DECISION DELEGATED TO DEVELOPMENT MANAGER

Application No:	H11-0595-20	Applicant:	Platform Housing Group
Proposal:	Proposed re-development of existing haulage yard for 40 dwellings - approved under H11-0916-16. Modification of Condition 2 to allow amendments to previously approved plans to accommodate a revised water line.		
Location:	Station Road (Former Nene Transport) Long Sutton Spalding		
Terminal Date:	12th November 2020

CASE OFFICER ASSESSMENT**PROPOSAL**

## BT11 - 2b4p House & 1b2p Apartment - Applicable to Plots 37-39

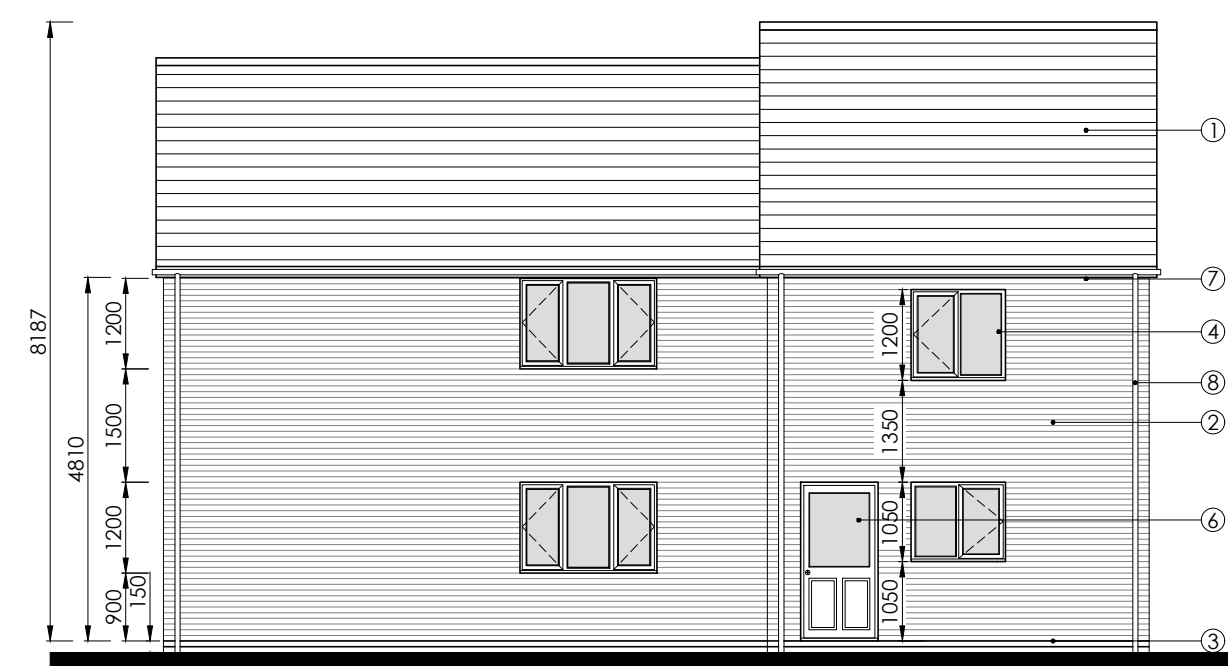
The key plots impacted by this change are plots 22, 32, 33, 37, 38, 39 and 40. The remaining plot locations and layout are unchanged.

Plots 37, 38, 39 - These dwellings are within the site and do not have direct boundaries with neighbouring dwellings that would be impacted.

Title:
Alternative Drainage Strategy

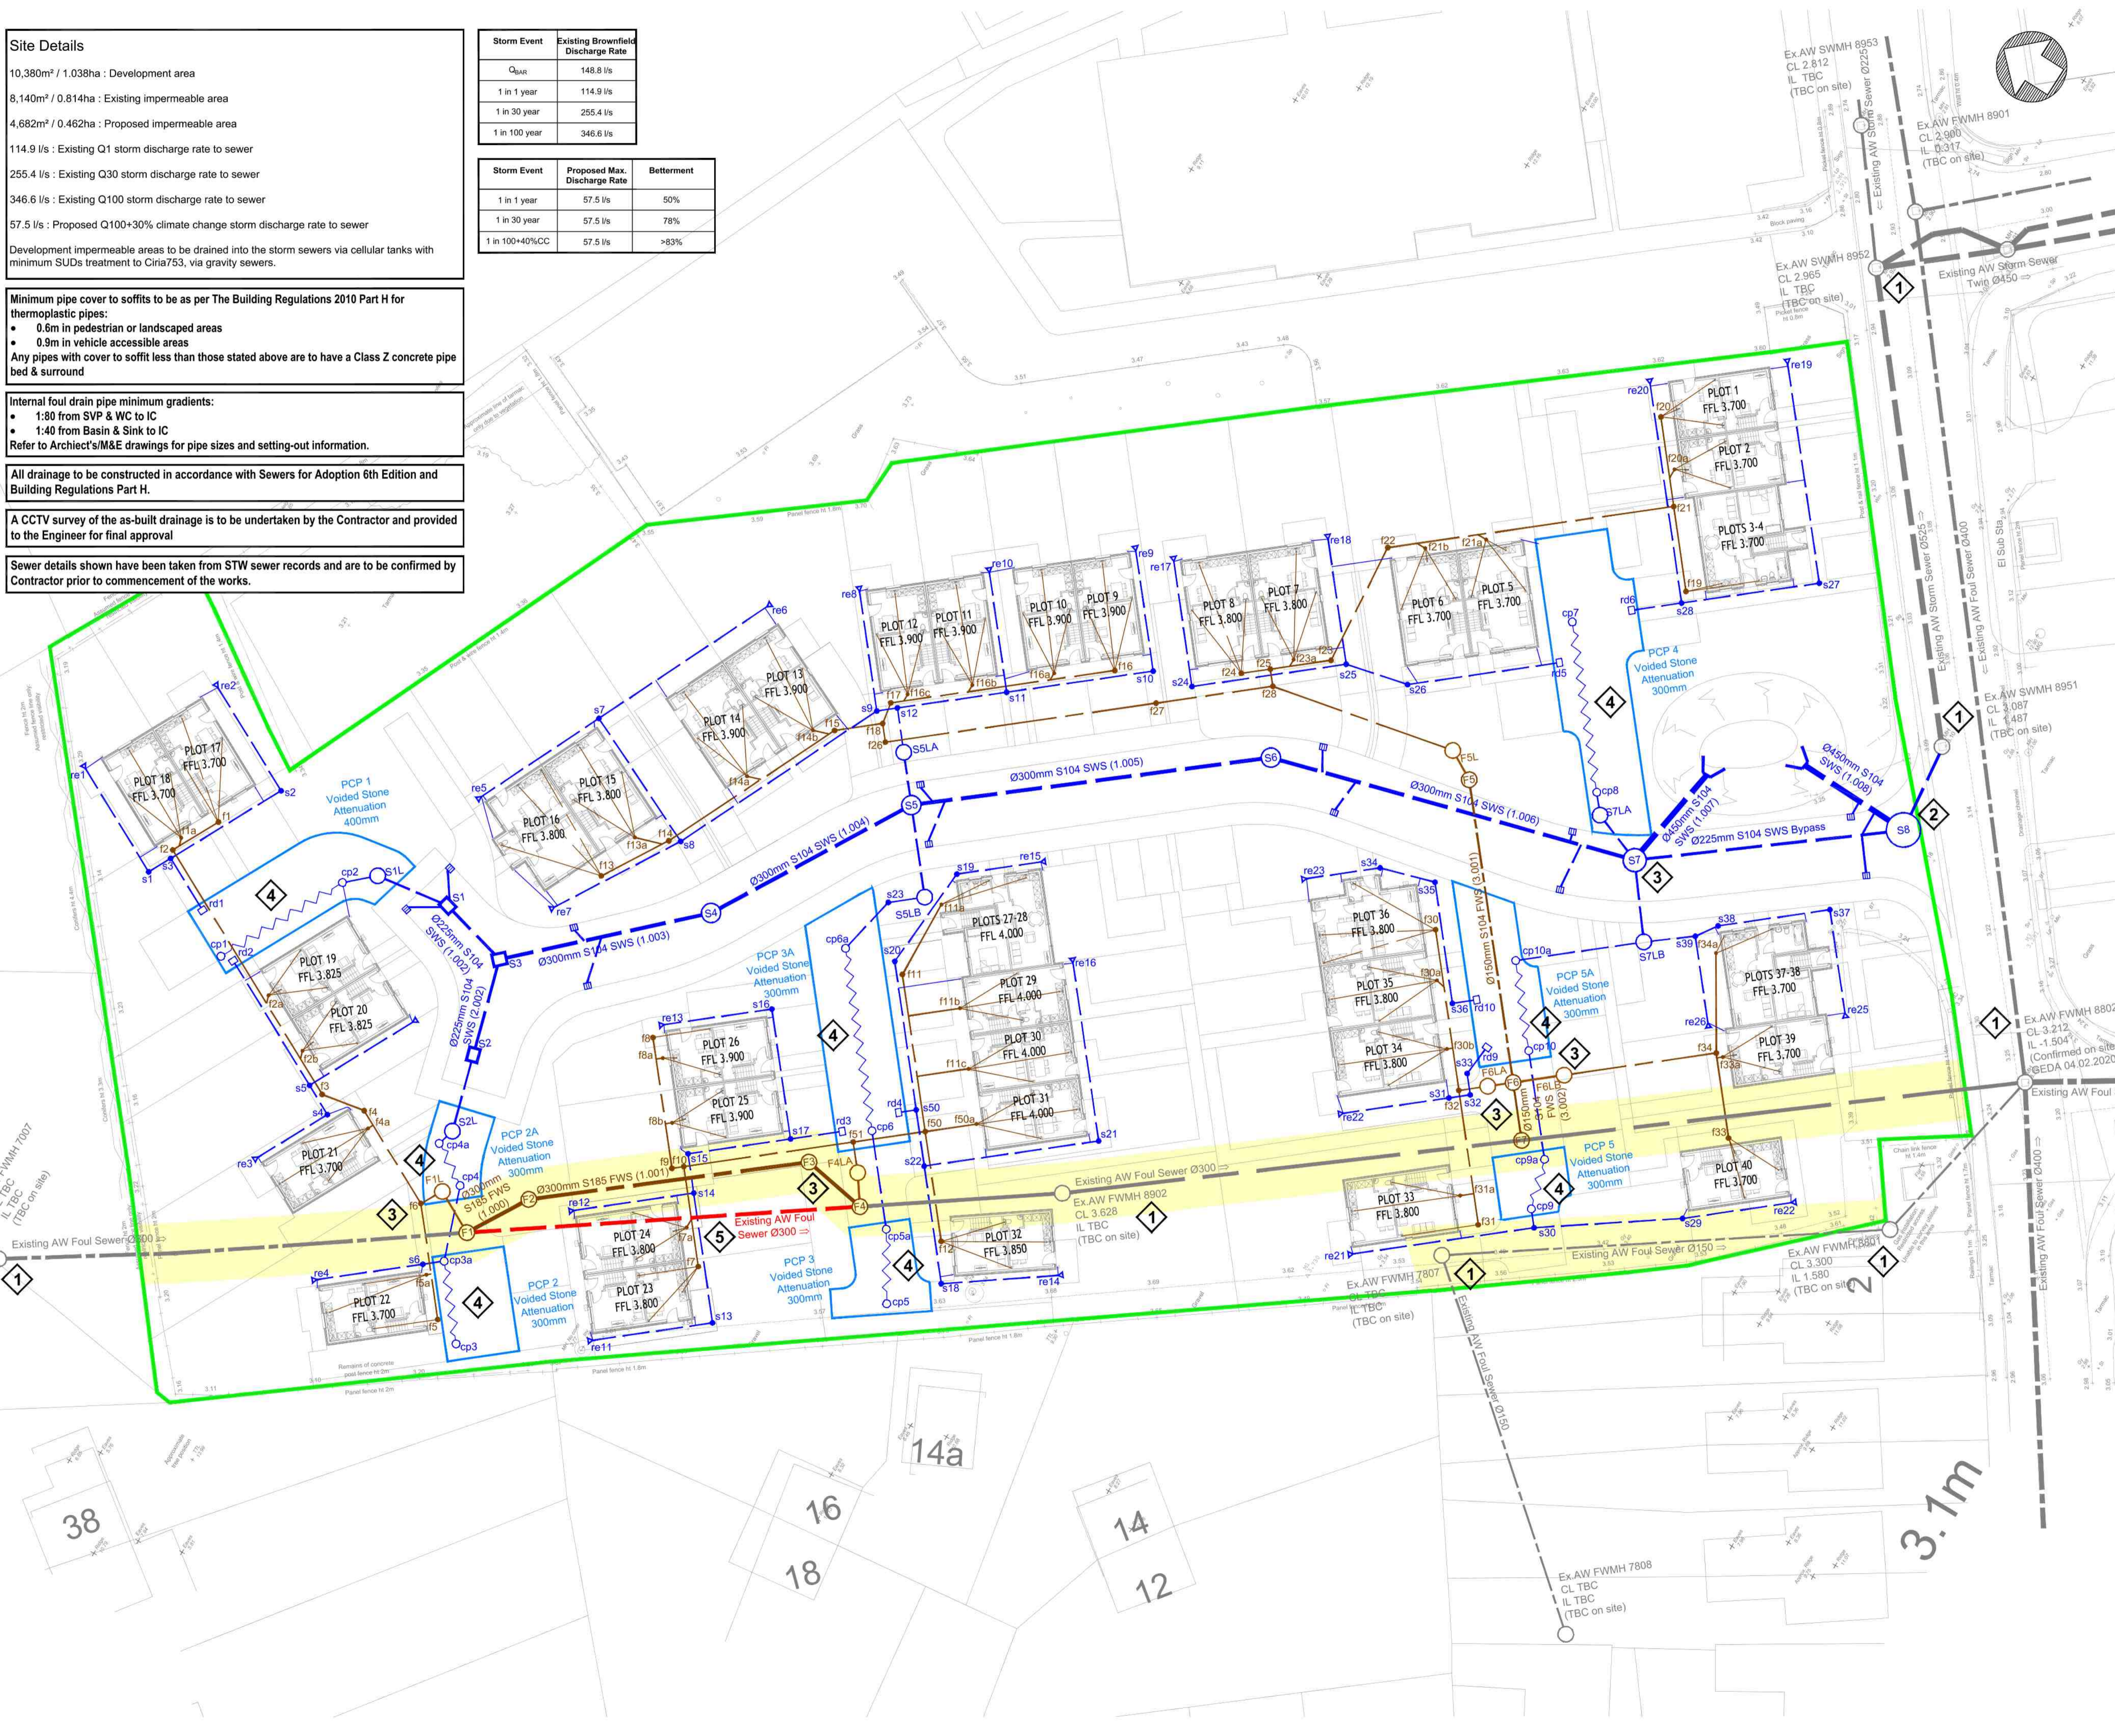
This application proposes the redesign and realignment of certain plots as the ground conditions on site are unable to support the sewer in the position as originally planned for. The applicants have been working closely with Anglian Water to determine the best position for this. The proposal is to reuse the majority of the existing sewer but they have had to alter the position of some of the dwellings to do this and have created some new house types as a result.

The foul drainage will be revised to show only the small length of diversion and lateral chamber will be constructed to connect into the existing foul sewer.

Anglian Water have raised no objections to the revisions.
